Re: Davis Road, Resource Recovery Centre - Response to Authorities Submissions

Northrop Consulting Engineers have prepared the following letter on behalf Bettergrow Pty Ltd, in response to the relevant authority's submissions in relation to the proposed Resource Recovery Centre at 24 Davis Road, Wetherill Park. Specifically, response to the submissions in relation to the Surface Water Assessment from the NSW Planning and Environment Department and the Fairfield City Council have been provided.

This letter should be read in conjunction with our Surface Water Assessment report dated 21/02/2017 [Revision D] and our amended drawing set NL151740_C00 – C03 dated 14/07/2017.

DRAWING TITLE
EROSION AND SEDIMENT CONTROL PLAN

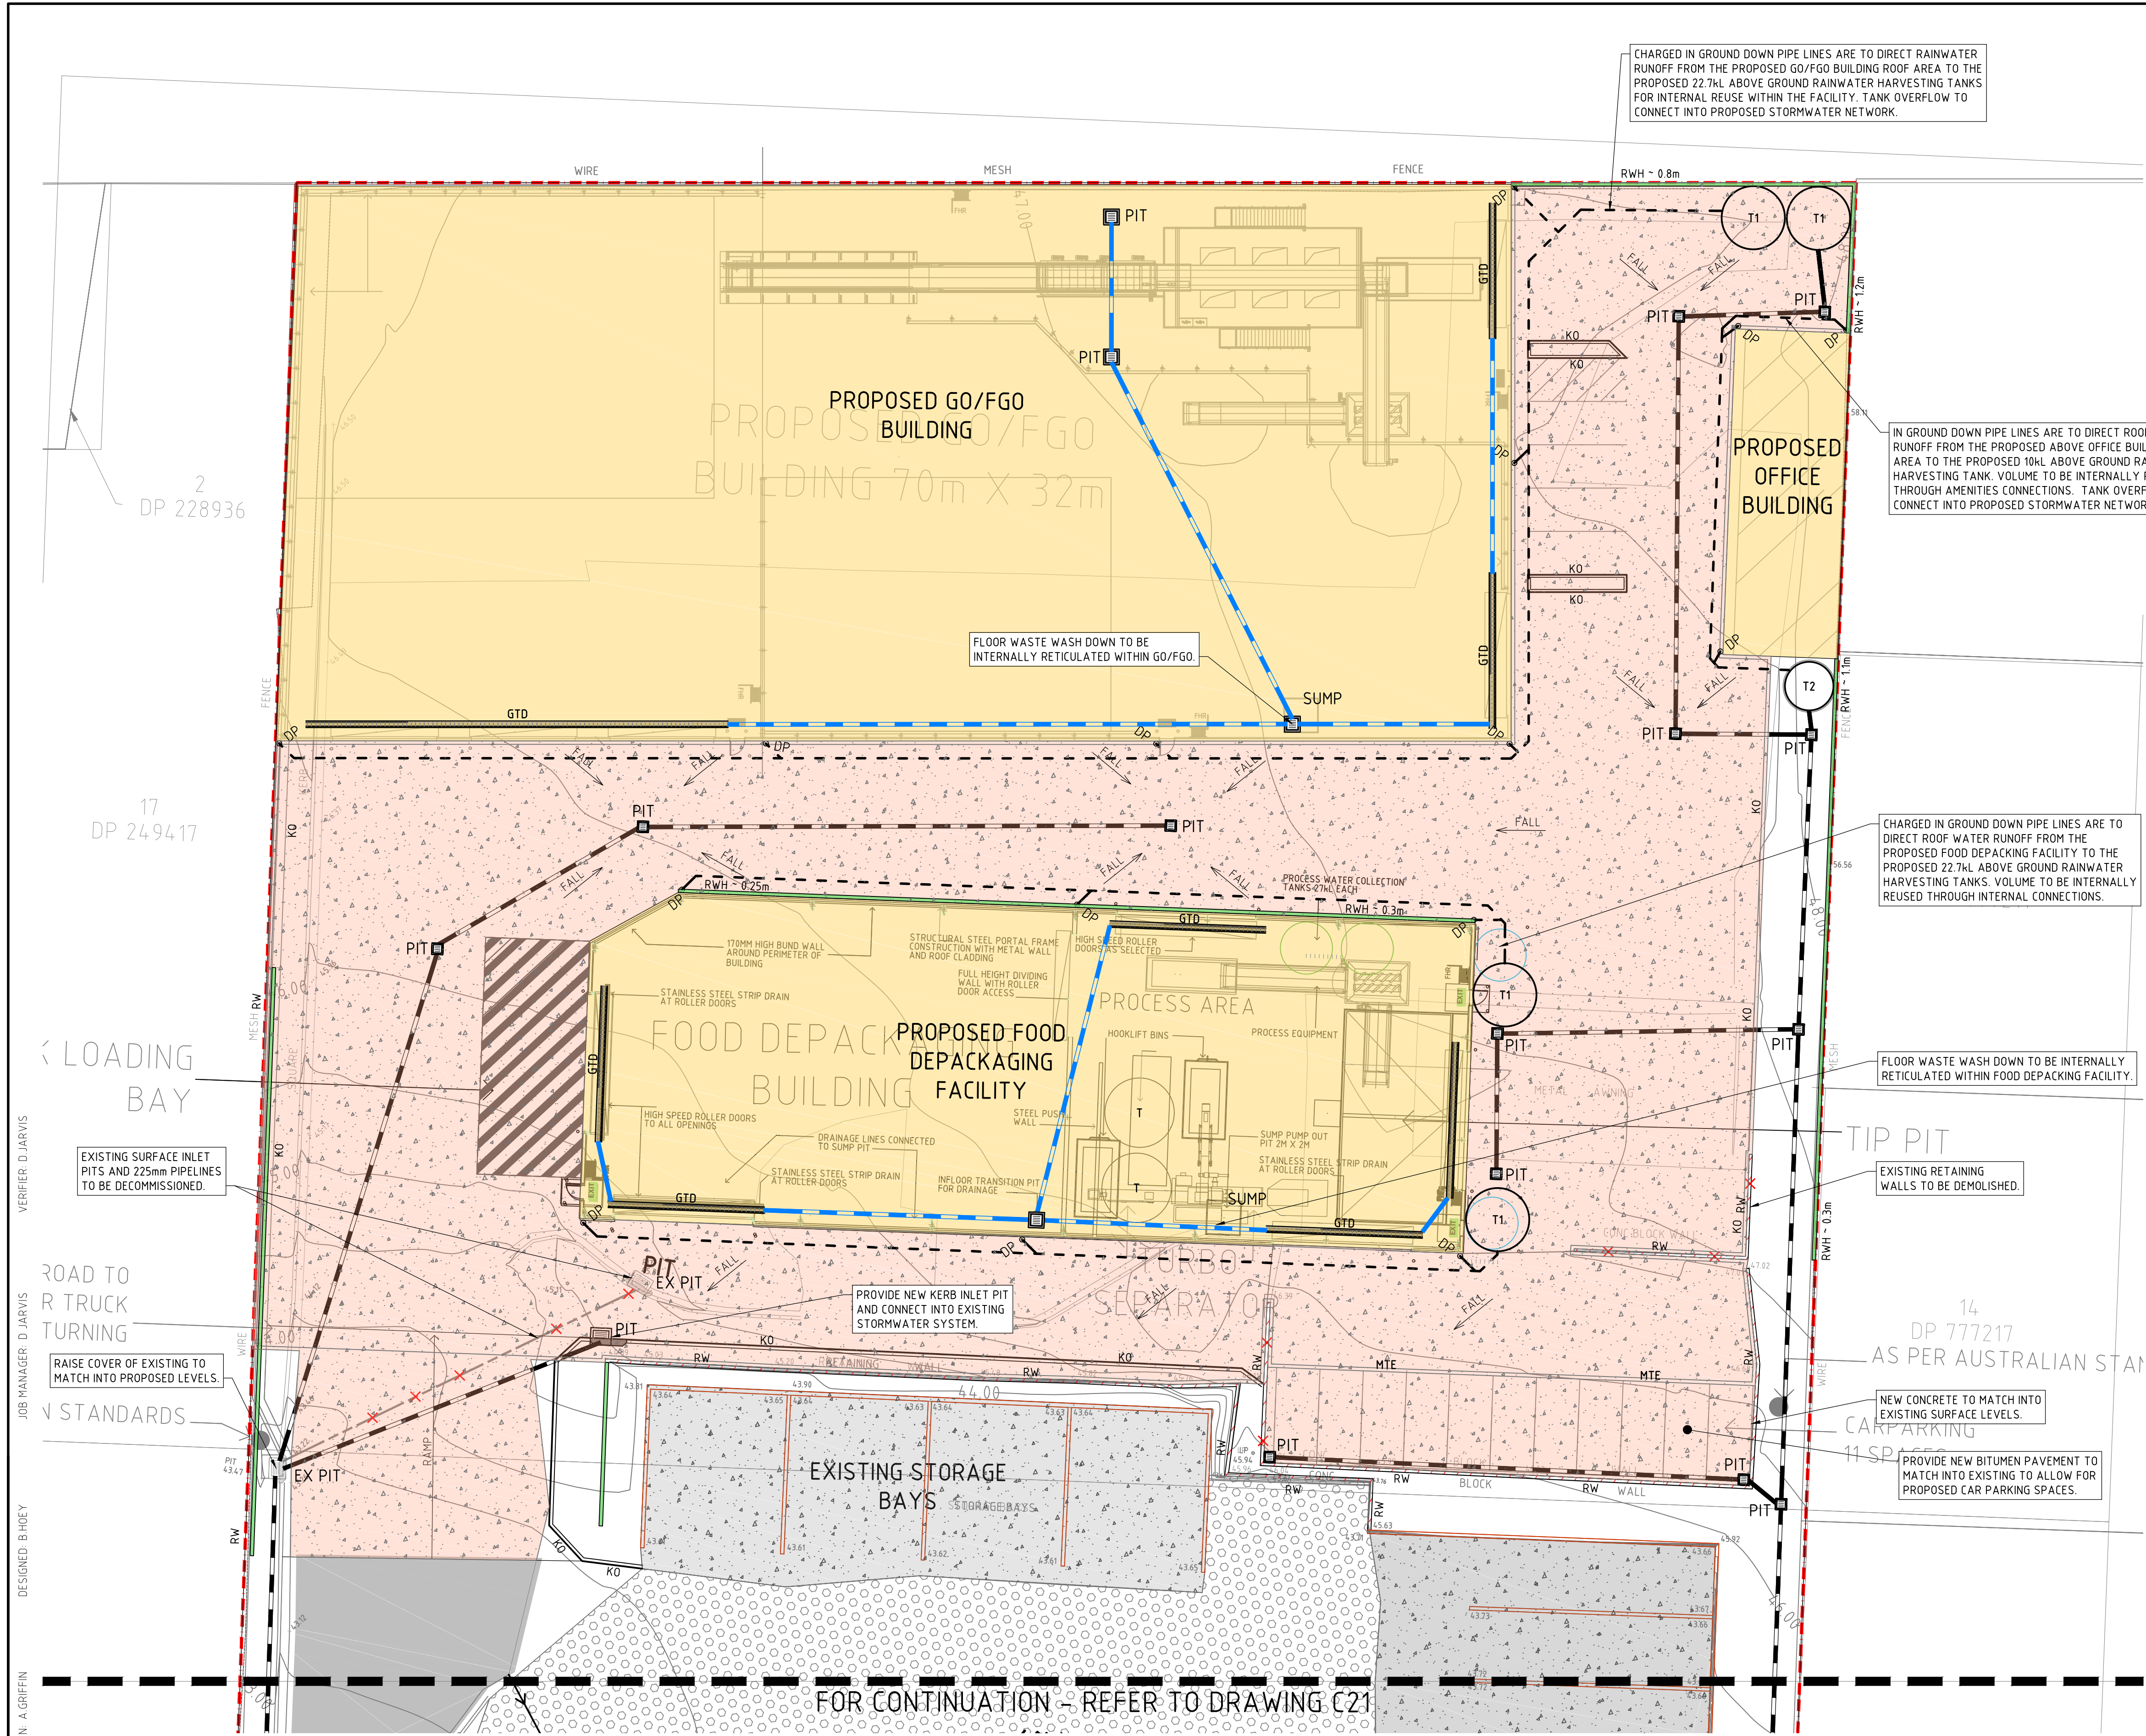
Comment: 5. Figure 42 of EIS, shown a stockpile located on the gravel area in the landscaping area. Please detail the height stockpiles and why stockpiles are not located within designated bays.

Response: The referenced stockpile shown on the Erosion and Sediment Control Plan illustrates the indicative location of a temporary material stockpile to be utilised by the civil contractor during the construction phase only. The location of the temporary stockpile will be subject to the contractor's requirements during the construction phase. The temporary stockpile has been depicted to illustrate that materials can be adequately stored onsite during construction with the required controls in accordance Landcom's Managing Urban Stormwater: Soils and Construction 'Blue Book' Guidelines.

These Guidelines currently represent best practice management for developments within NSW during construction and are thus recommended for adoption. In accordance with 'Blue Book' requirements material stockpiles are to be no more than 2m high. This temporary stockpile location will not be used during the operational phase of the project. Further to this, we clarify that all measures proposed on the Erosion and Sediment Control Plan are to be temporarily installed throughout construction and removed once the site has been stabilised.
